Our ref: DOC19/929355
Senders ref: SSD 10344

Subject: New Request for Advice – Bella Vista Station Precinct Concept Proposal (SSD 10344) (The Hills Shire)

Figure 40 | Baseline flood condition showing flooding during the 100-year ARI to a small portion of the site in the vicinity of the creek.
(Source: Applicant's EIS)

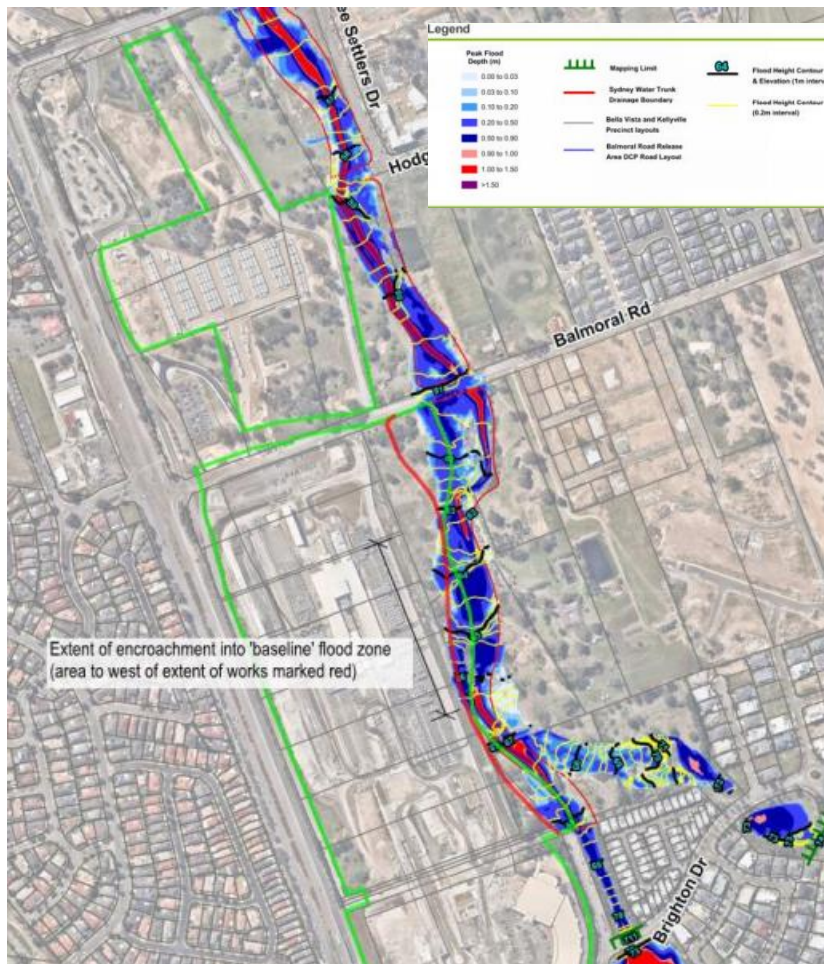
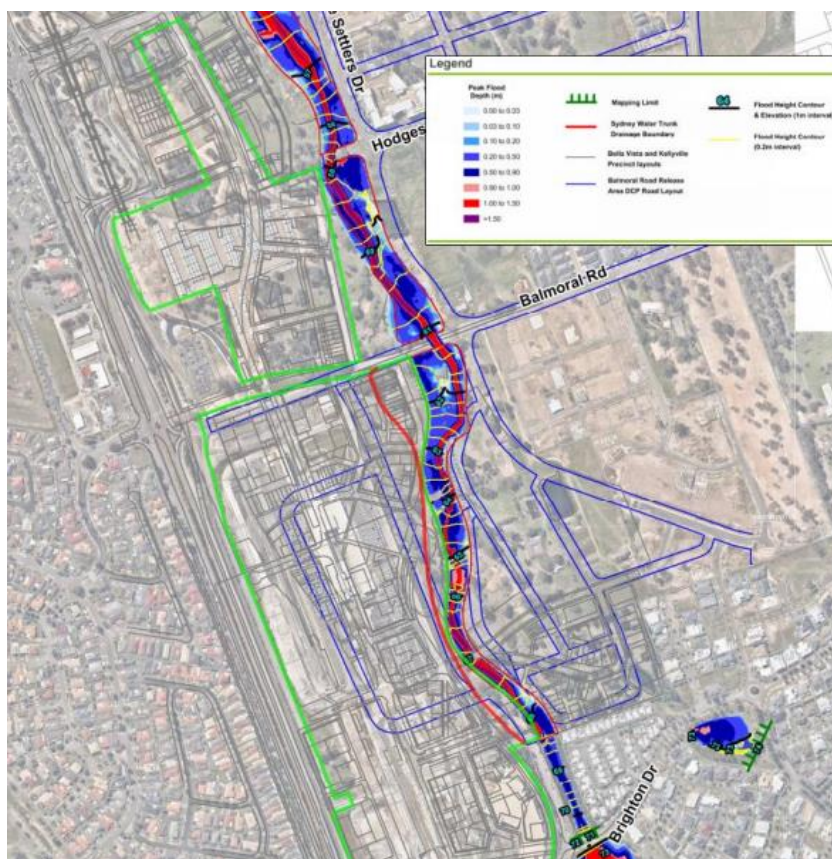
The Stormwater Management Plan prepared by Stantec dated September 2019 does not include a flood impact assessment, though it refers to Sydney Water's Trunk Drainage Concept Design Report as a flood assessment.

The Sydney Water Elizabeth Macarthur Creek (EMC) Trunk Drainage Concept Design Report is not considered a flood impact assessment report, as its purpose is to design and document the preferred trunk drainage concept design for EMC.

Accordingly, a flood impact assessment should be undertaken to adequately address the above points.
